Addendum No. 2

RE: Contract # C204507

Cumberland County (U-5798A)

SR-1102 FROM NORTH OF SR-1112 TO US-401 AND REPLACE BRIDGE
250075 OVER LITTLE ROCKFISH CREEK.

POUR #2  
UPPER PART OF WINGS AND BACKWALL 14.4 C.Y.

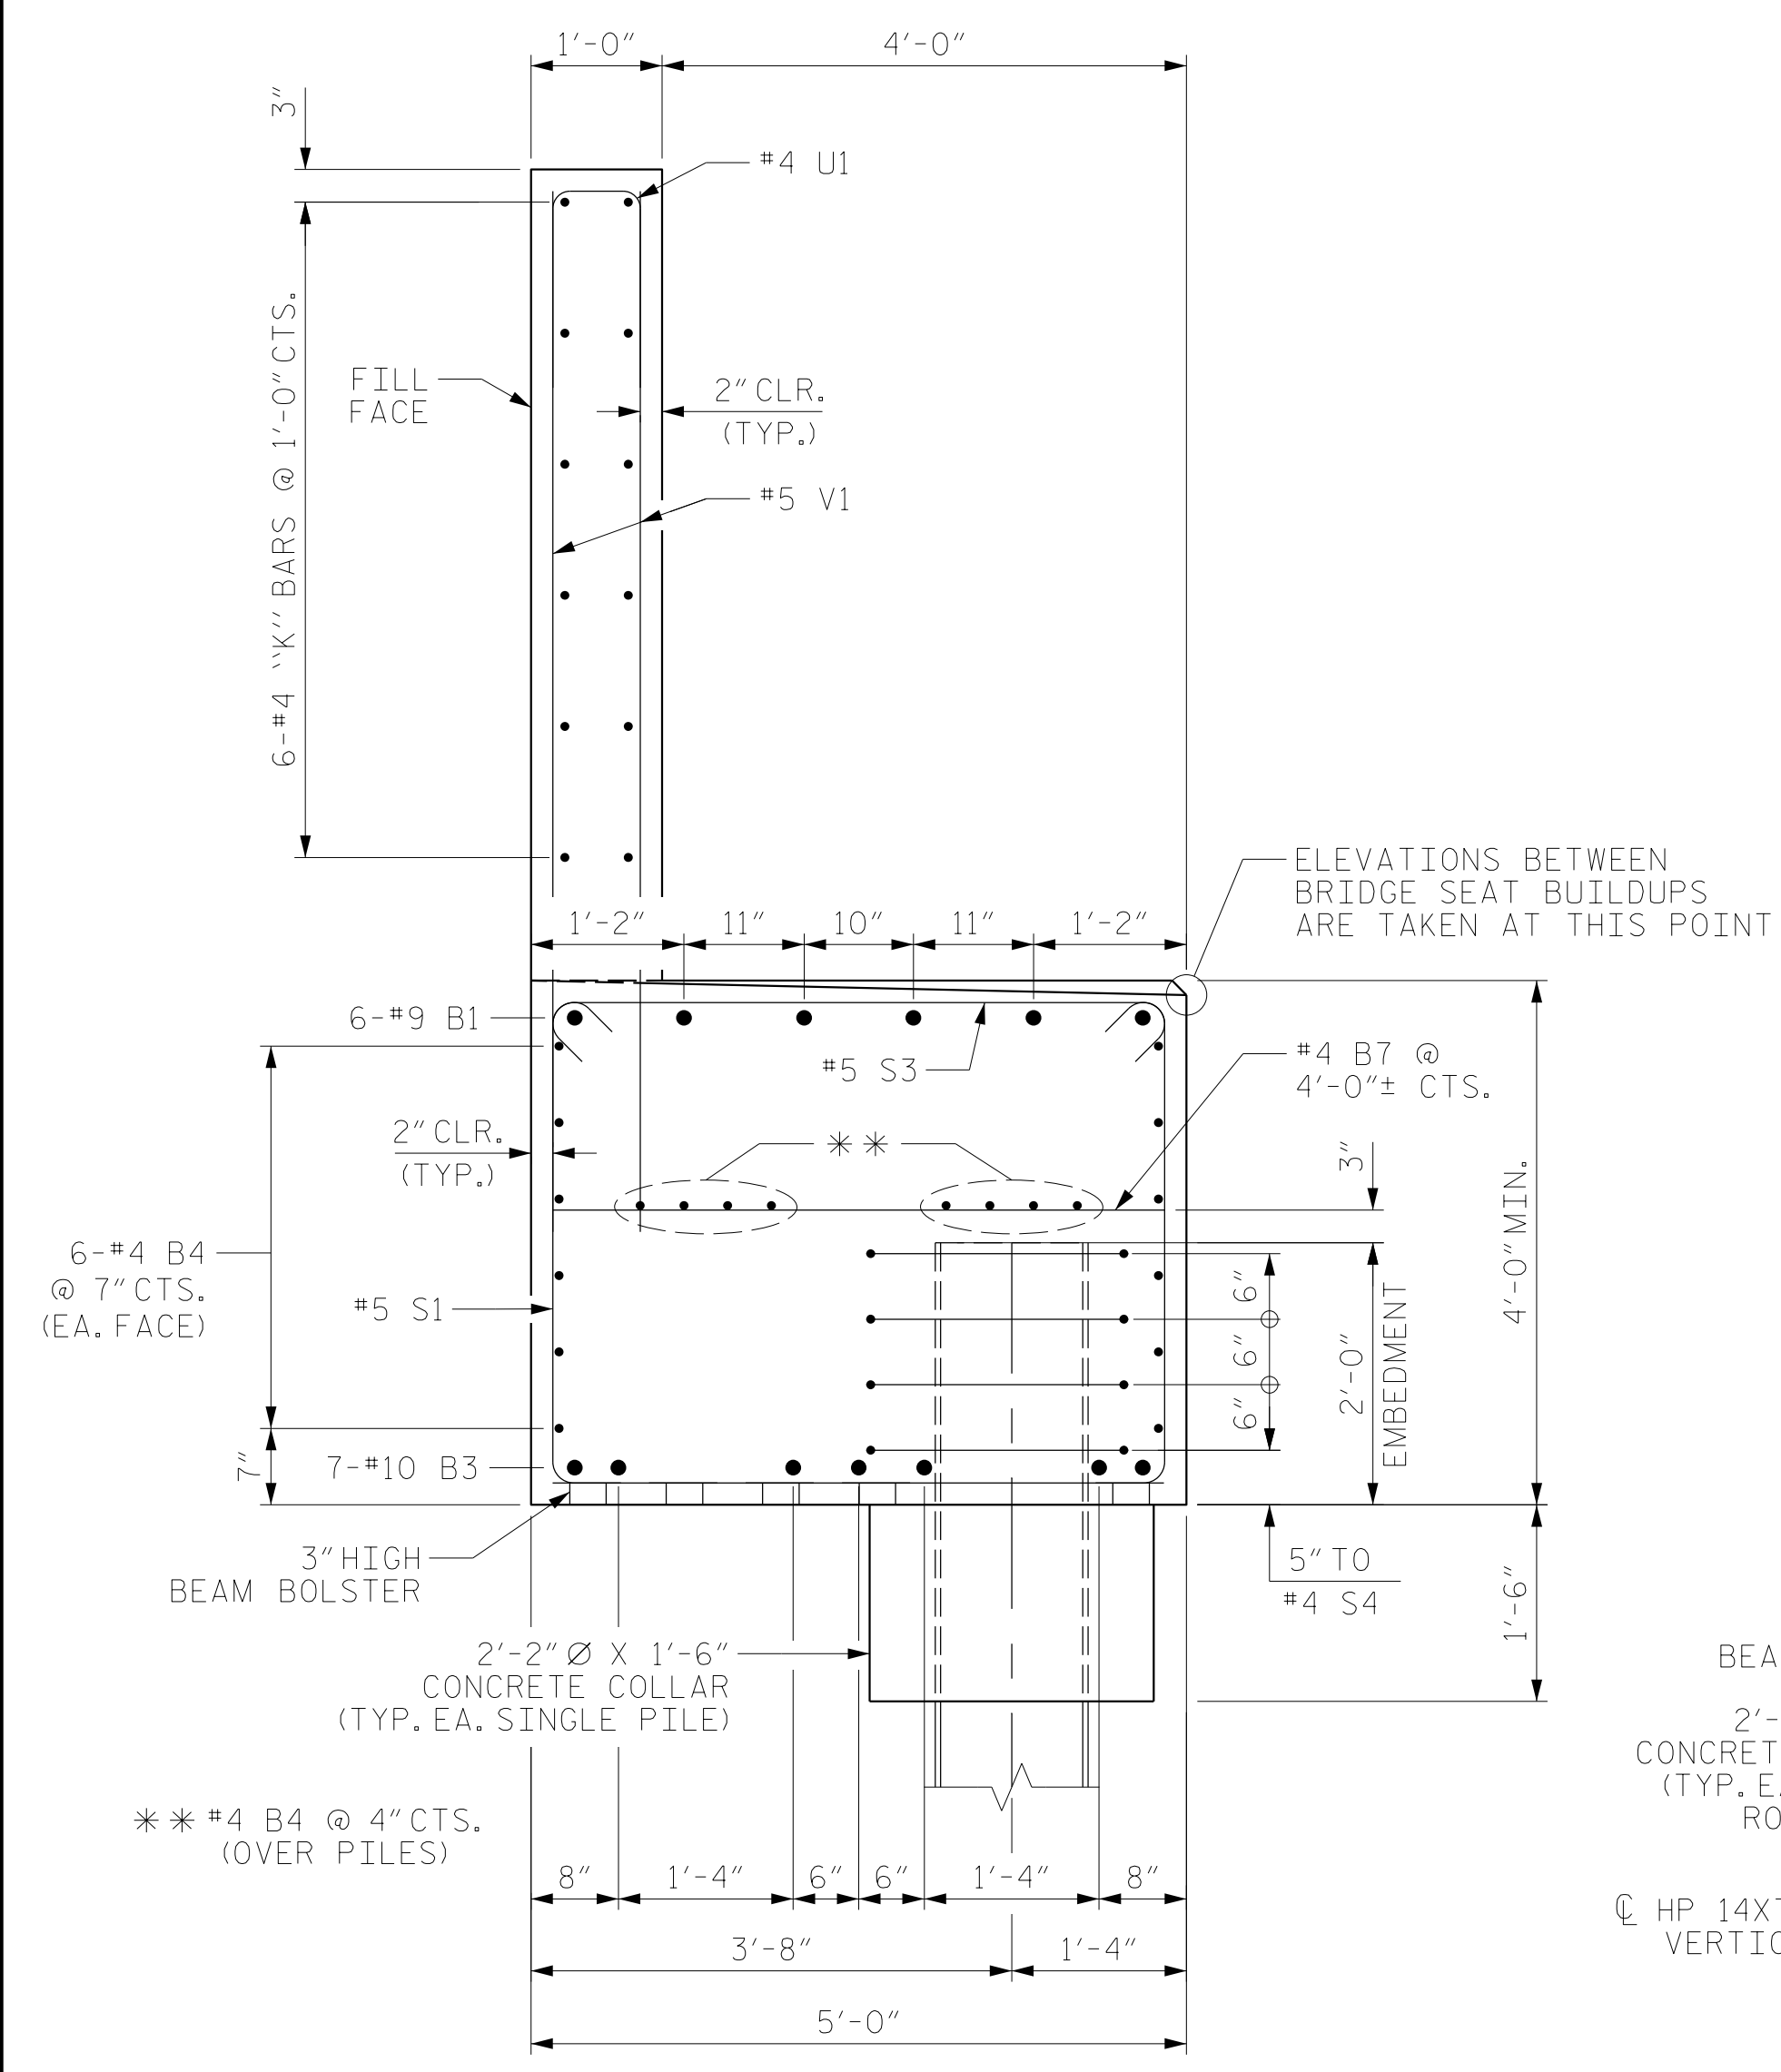
Sheet No.	Revision
S1-3	Updated to reflect quantity changes.
S1-33	Updated to reflect quantity changes.
S1-39	Updated to reflect quantity changes.
S2-3	Updated to reflect quantity changes.
S2-33	Updated to reflect quantity changes.
S2-39	Updated to reflect quantity changes.

<u>Item</u>	<u>Description</u>	<u>Old Quantity</u>	<u>New Quantity</u>
0240-8328200000-E-450	PILE DRIVING EQUIPMENT SETUP FOR HP 14 X 73 STEEL PILES	40 EA	44 EA
0242-8384000000-E-450	HP 14X73 STEEL PILES	2,580 LF	2,840 LF
